Monument Glamping II

Special Use Application

Letter of Intent

PCD File No.: AL2318

SITE PLAN

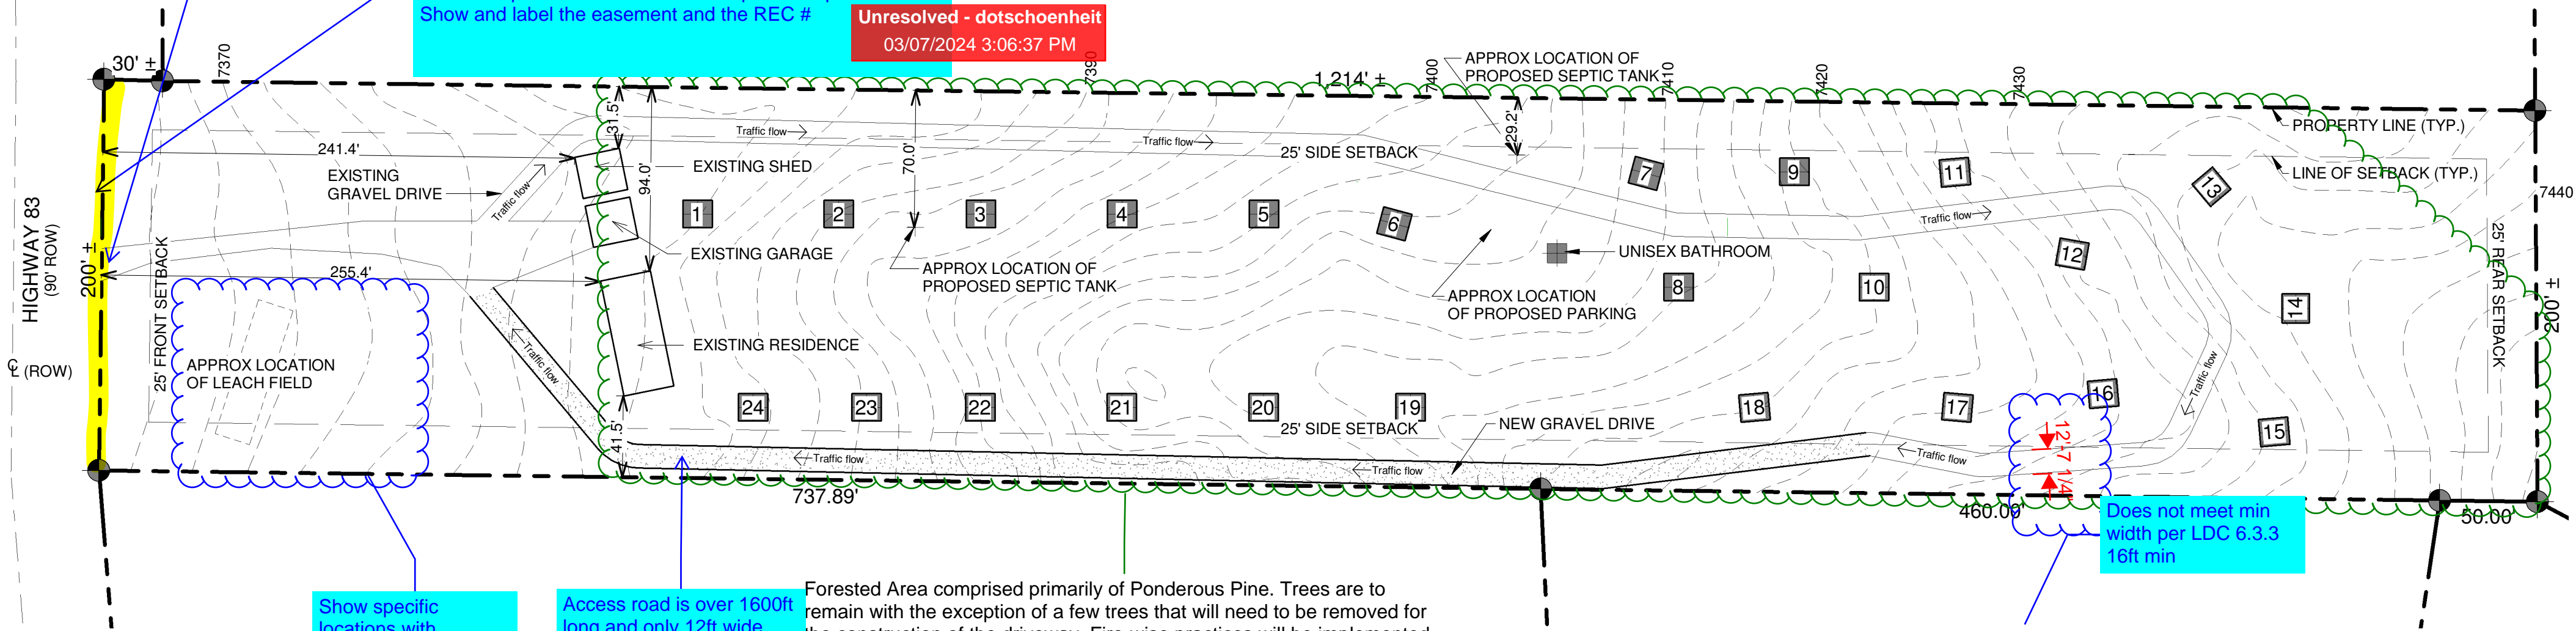
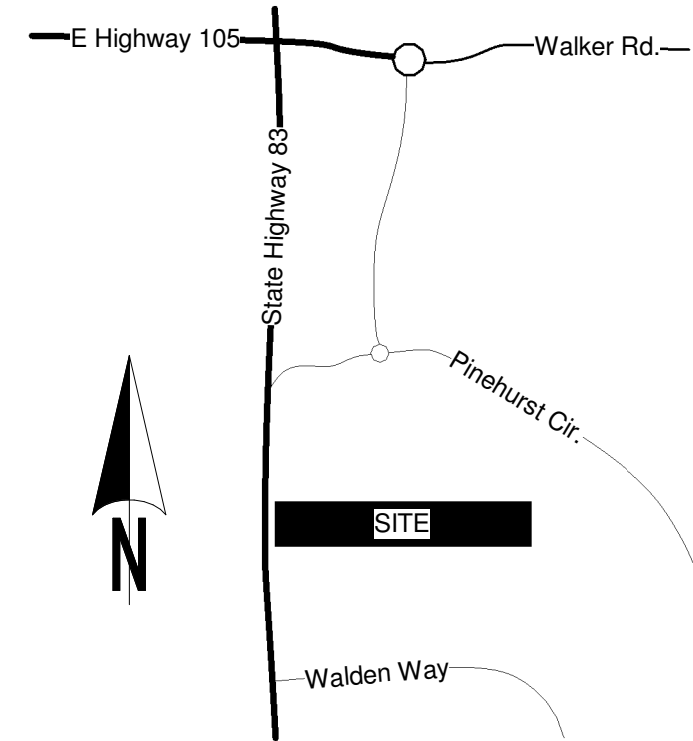
commercial septic
permit allows 12 sites
are 24 people max
please revise

Your commercial septic permit is for 12 sites and up to 24 people, 24 is too

RESPONSE: the
septic system is
being permitted
through EPC Health.

RESPONSE: the septic system is being permitted through EPC Health.
